**DECISION DELEGATED TO HEAD OF PLANNING**

**Application No:** H11-0972-25                      **Applicant:** Seagate Homes

**Proposal:** Details of landscaping & tree planting, a plan illustrating all areas of publicly accessible open space, boundary treatment or screening and details of treatments including the need for any retaining walls to be erected along the western boundary of the site adjoining 36 Lime Walk (Conditions 9, 11, 12 & 14 of H11-0289-25)

**Location:** Land At Lime Walk Long Sutton Spalding

LWLS-SH-PD-POS-1008 - No. 36 Boundary

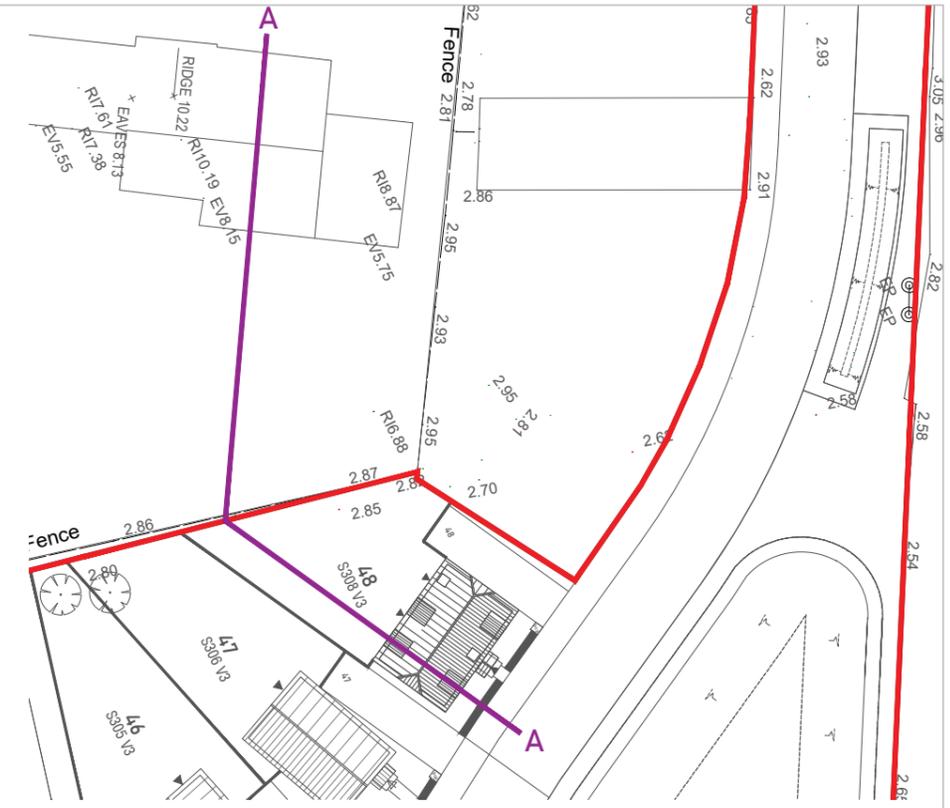
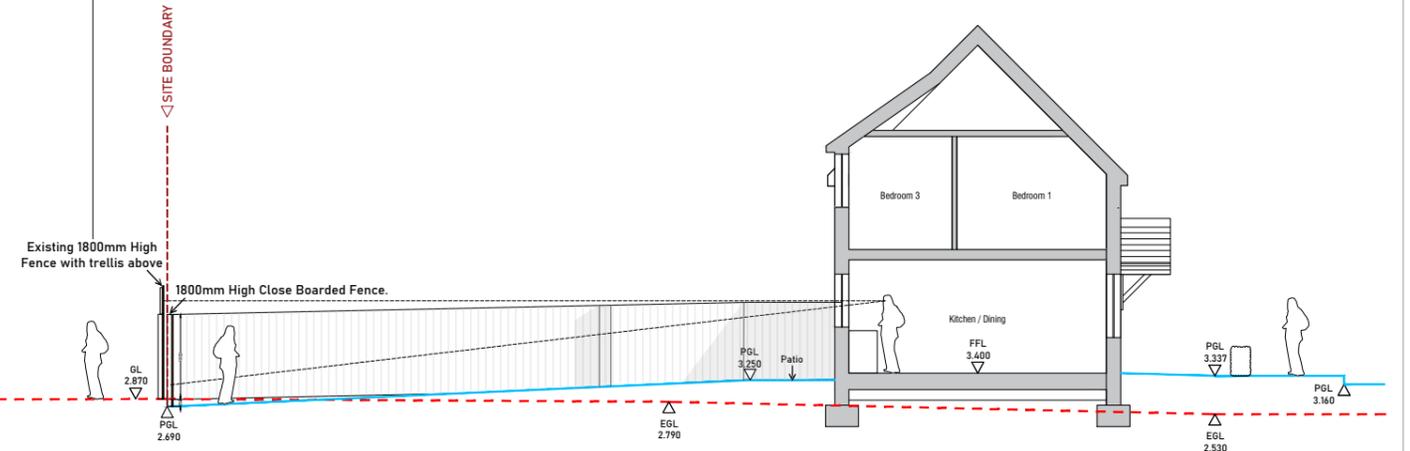
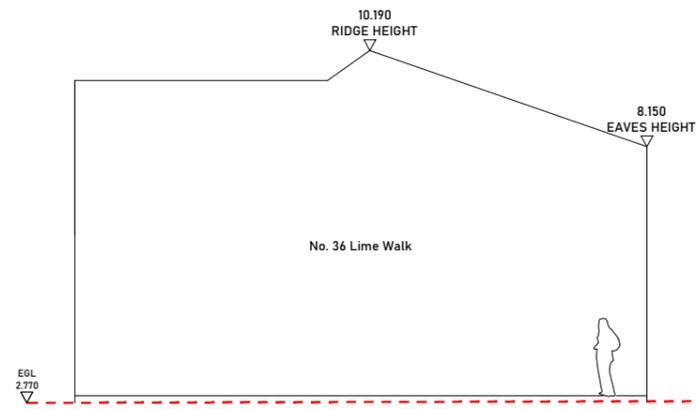
The plans provided both cross sectional drawings as well as site plan that shows a 1.8m fence (made up of 1.5m close boarded and 300mm of trellis) that exists on this boundary. The applicant has shown that this will be retained. The approach is considered acceptable.
